**PROPOSED MODIFICATION OF THE MIXED DEVELOPMENT USE AT NO. 157**  
**REDFERN STREET, REDFERN**  
**MP 09 0039 MOD 1**

To determine a modification request for the mixed development project approval (MP09\_0039 MOD 1).

Roof

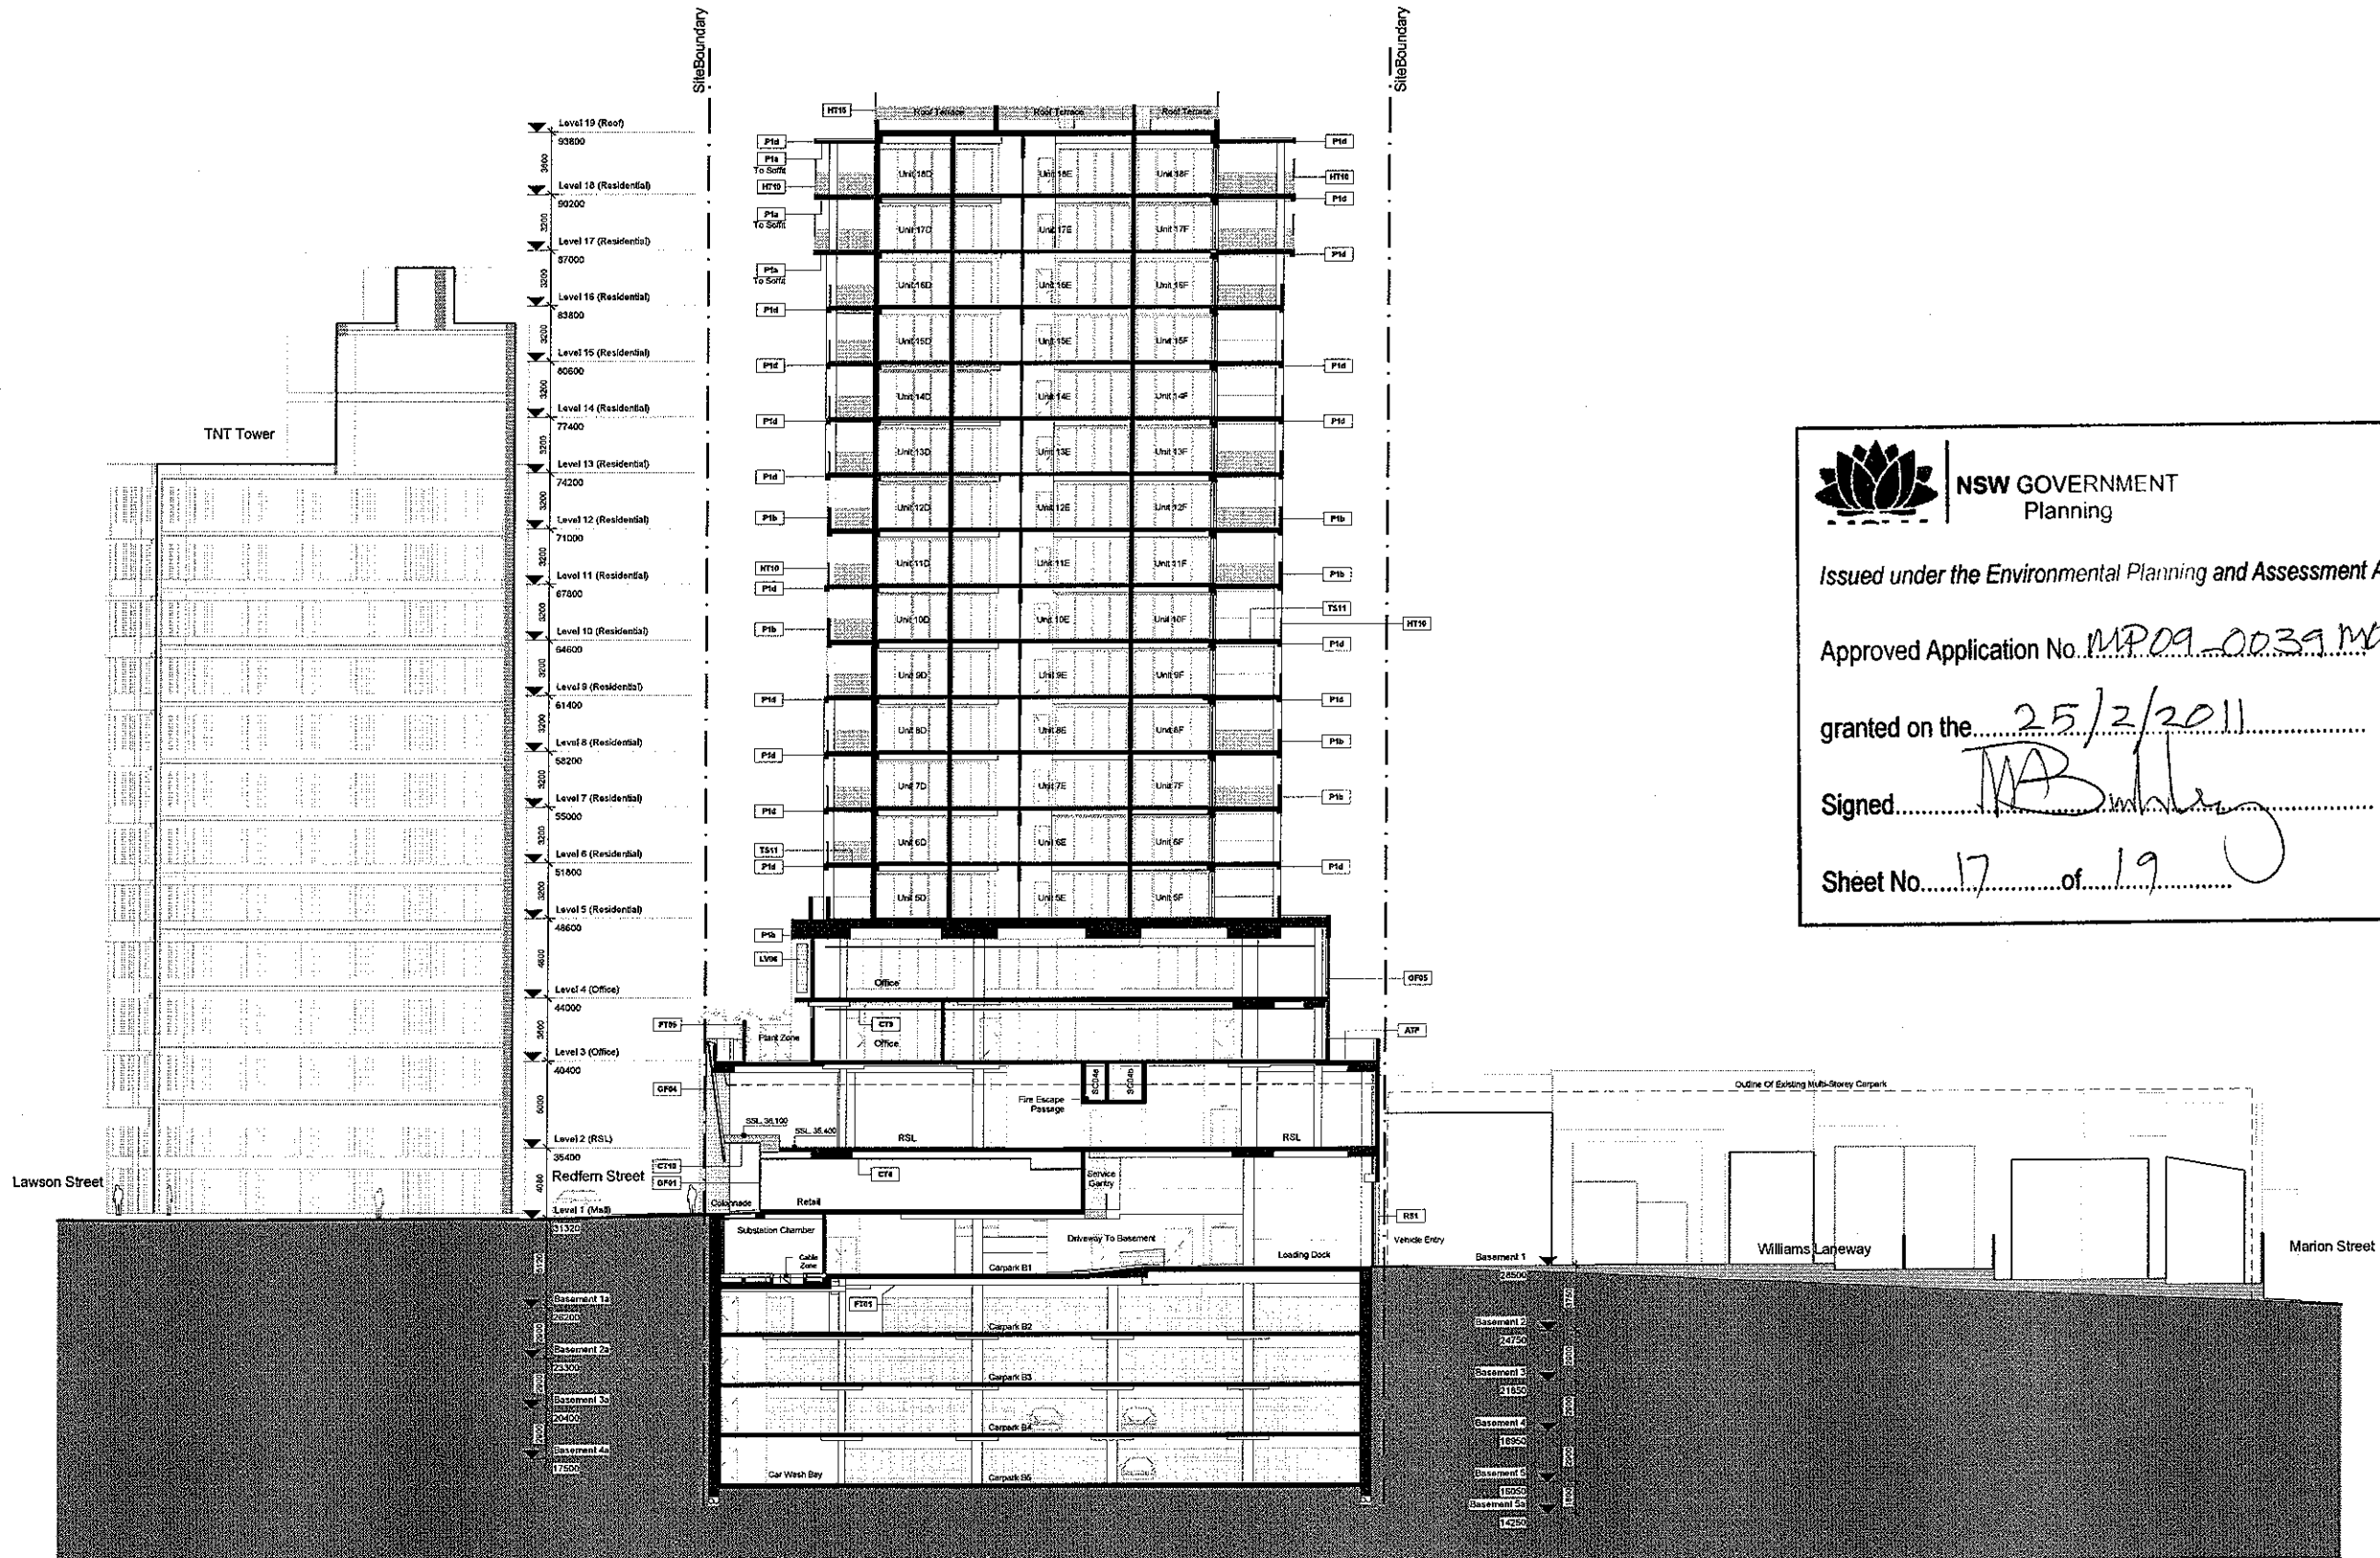
The current building height is proposed to be increased by 425mm, which is the lift overrun. This has occurred due the current provider of the lift system having withdrawn from the project. The new provider of a lift system, which is the closest to the present design requirements is able to accommodate the lift, but at an increased height.

The Department have viewed this variation and raised no objection as the overall height remains at 18 storeys and will not compromise the requirements of CASA in terms of the Obstacle Limitation Surfaces map.

South & West Elevations

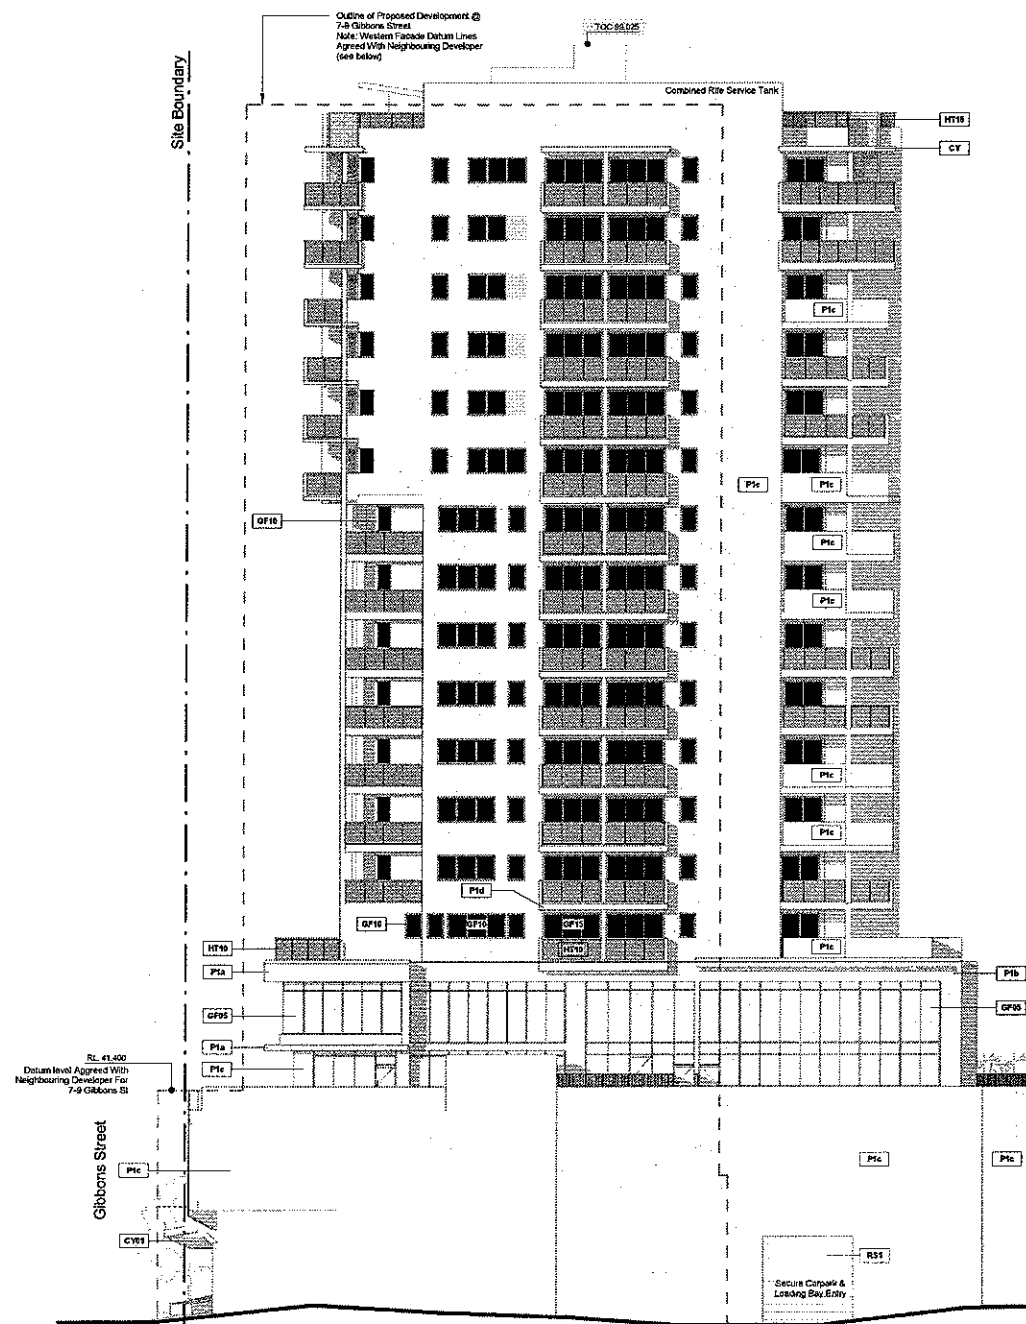
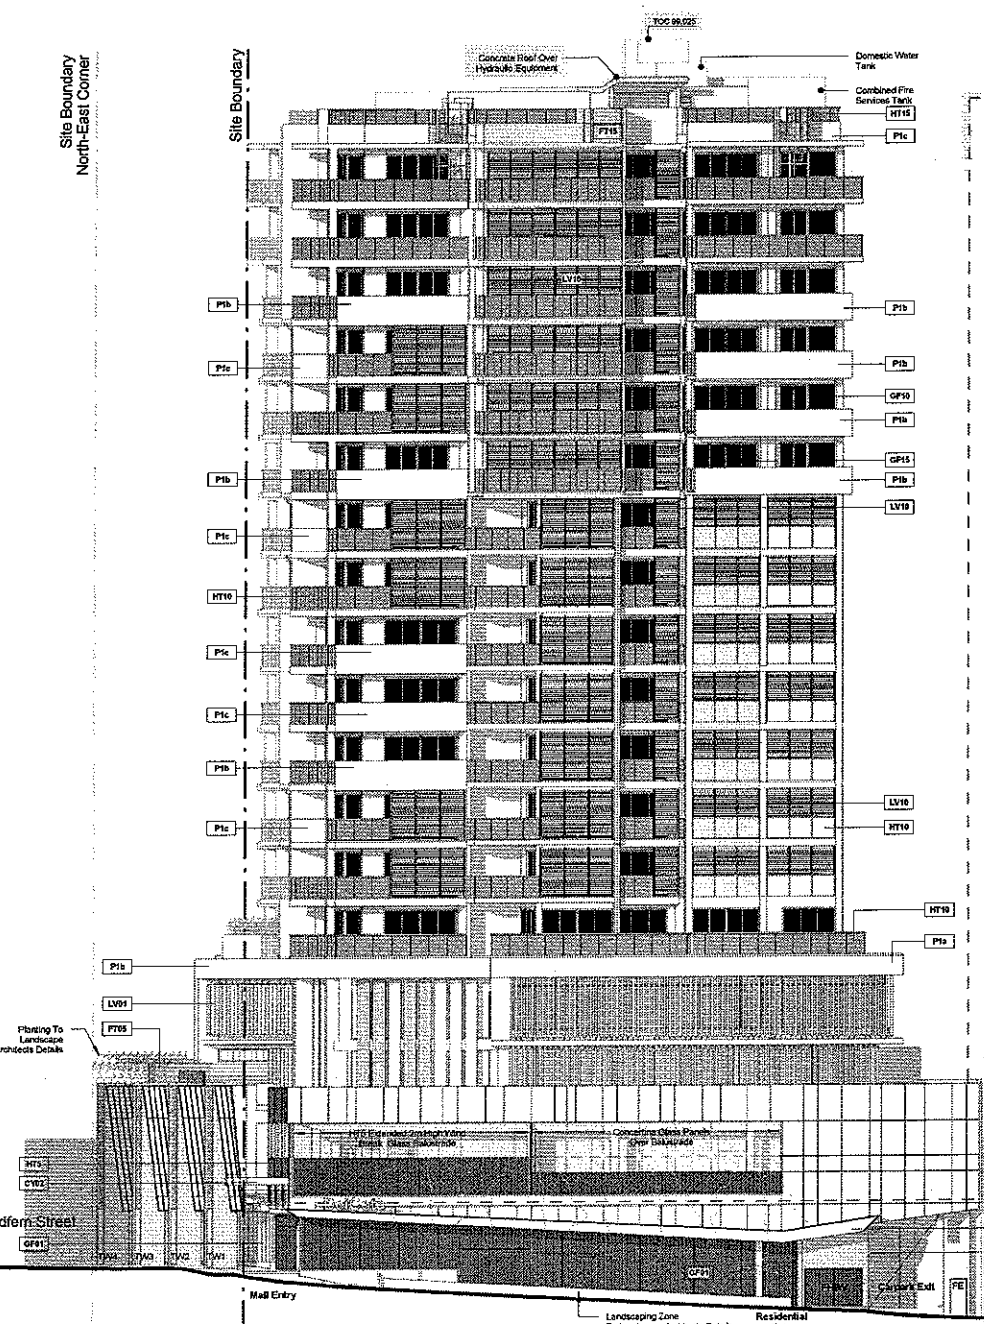
The proponent submits that the modifications proposed involve the following non-compliant reductions in the approved building's setbacks from Gibbons Street at levels 13 to 18:

- the setback of the main wall of the building is to be reduced from a minimum of 3.67m in the area where the balconies are to be enclosed, to 2.585m; and
- the setback of balconies is to be reduced from 2.585m to 0.82m.

The reduced setbacks are to occur only on parts of five (5) levels of the approved building, namely levels 13 to 18, with the underside of level 13 being some 44m above the footpath level in Gibbons Street (western elevation). The area in which the setback is to be reduced is to have an elevational area of 168m<sup>2</sup> in the western elevation, which has an overall area of 1,996m<sup>2</sup>. This represents some 8.4% of the building's western elevation (refer to **Figure 2** and **3**).

The Department is satisfied that, although the setbacks proposed are non-compliant, the setback encroachment at the upper levels 13 to 18 positively contributes the visual horizontal and vertical modulation of the western elevation without any detrimental impact on the streetscape or adjoining buildings.
